August 12, 2024

Re: Traffic Noise Addendum Letter
2928 Bank Street, Ottawa ON
GWE File No.: 24-062 – Noise Addendum Letter

- 1 OLA RECEPTOR
- 1 POW RECEPTOR

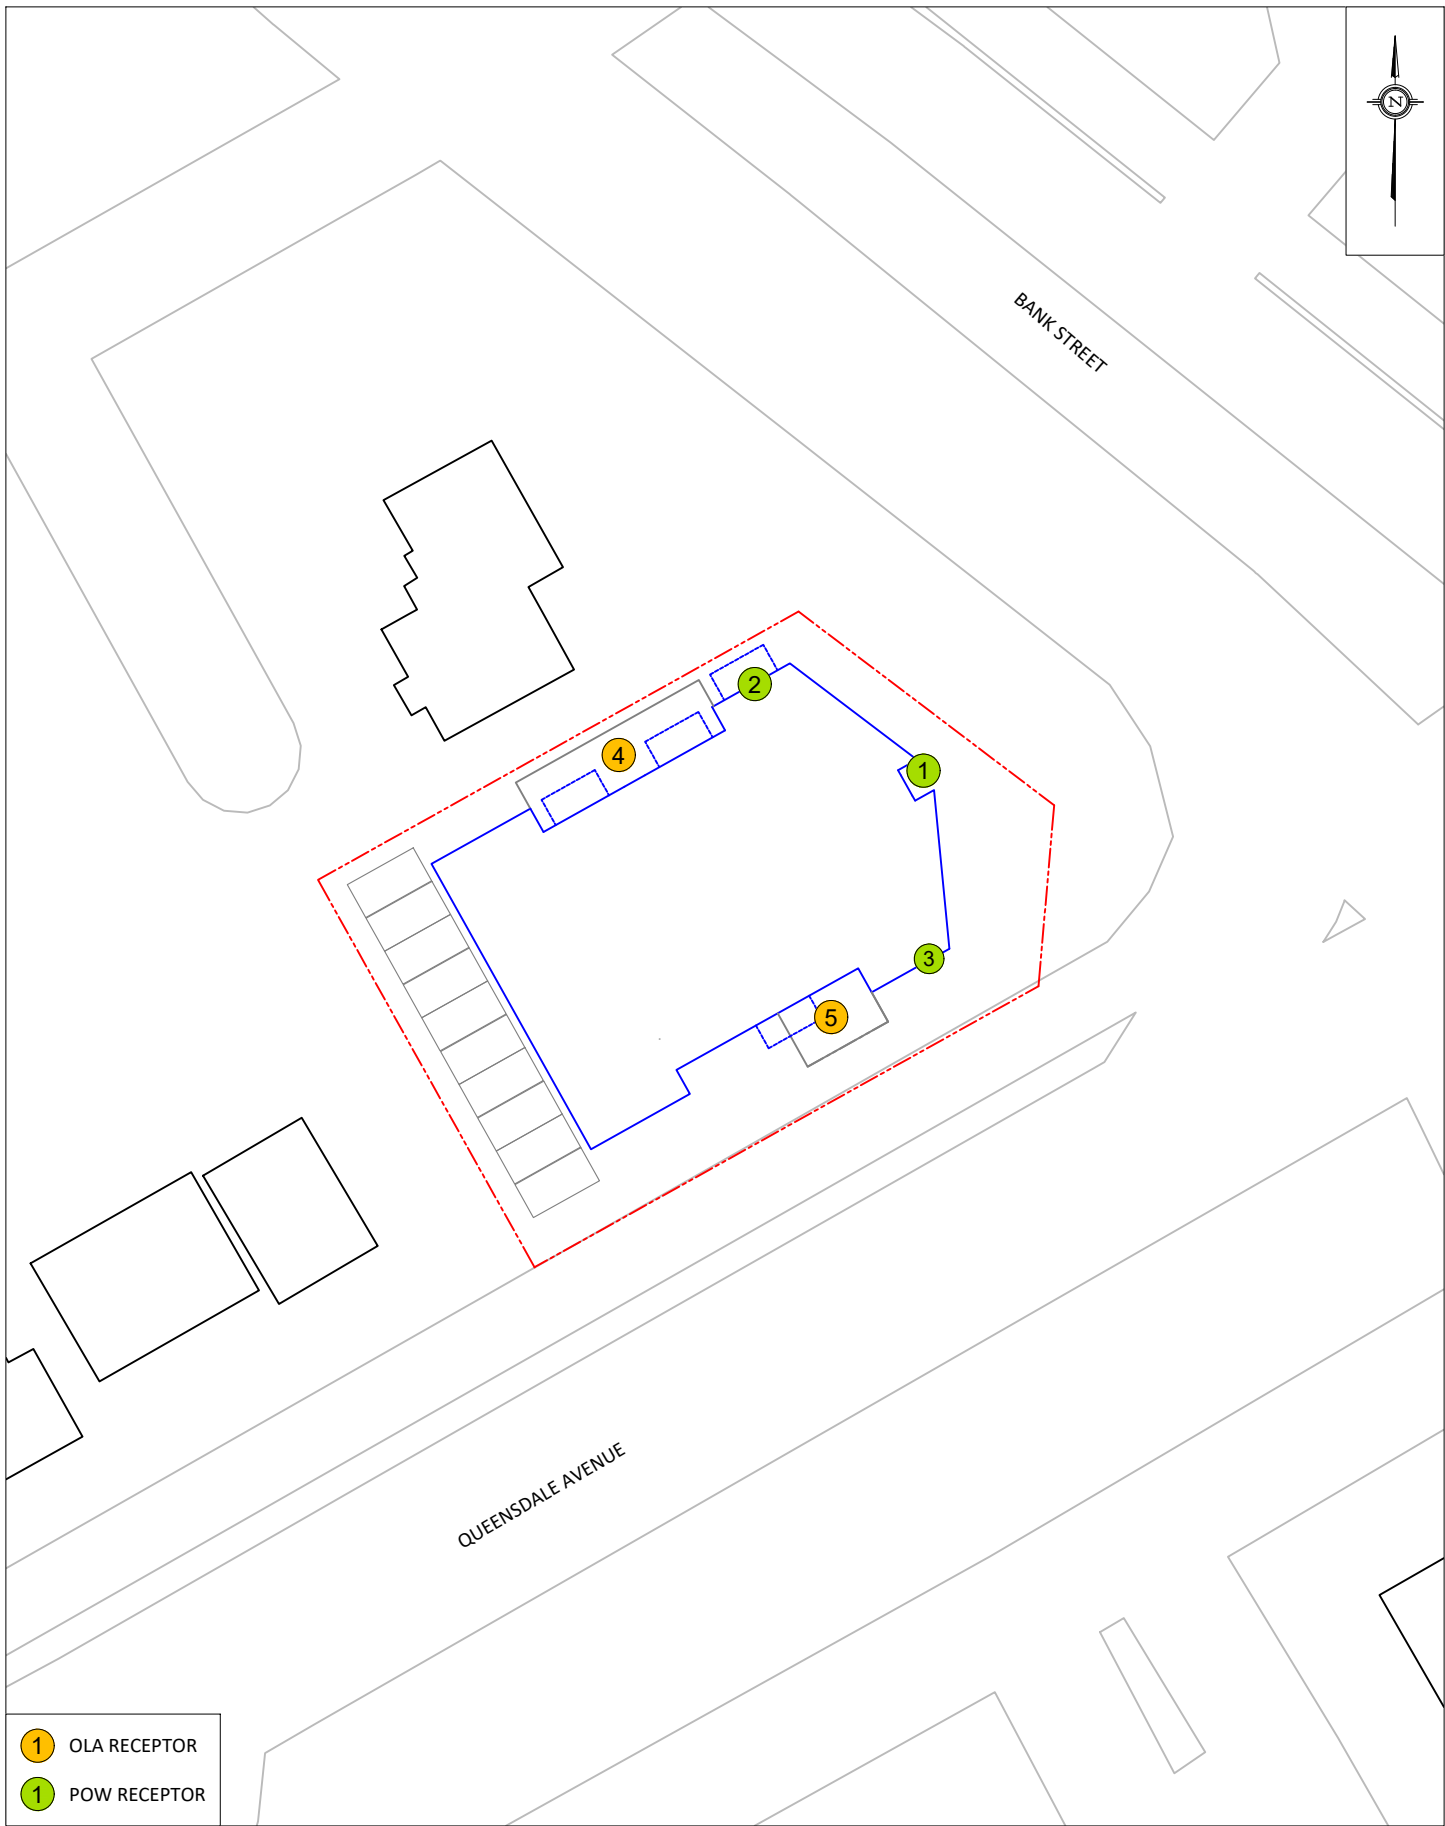
The terrace on the south side of the building as represented by receptor 5, is not intended for quiet enjoyment of the outdoors, and will function as a front landing for the main entrance of the apartment building. As such this area is not considered as an outdoor living area, therefore the original recommendation of providing a noise barrier is now considered null.
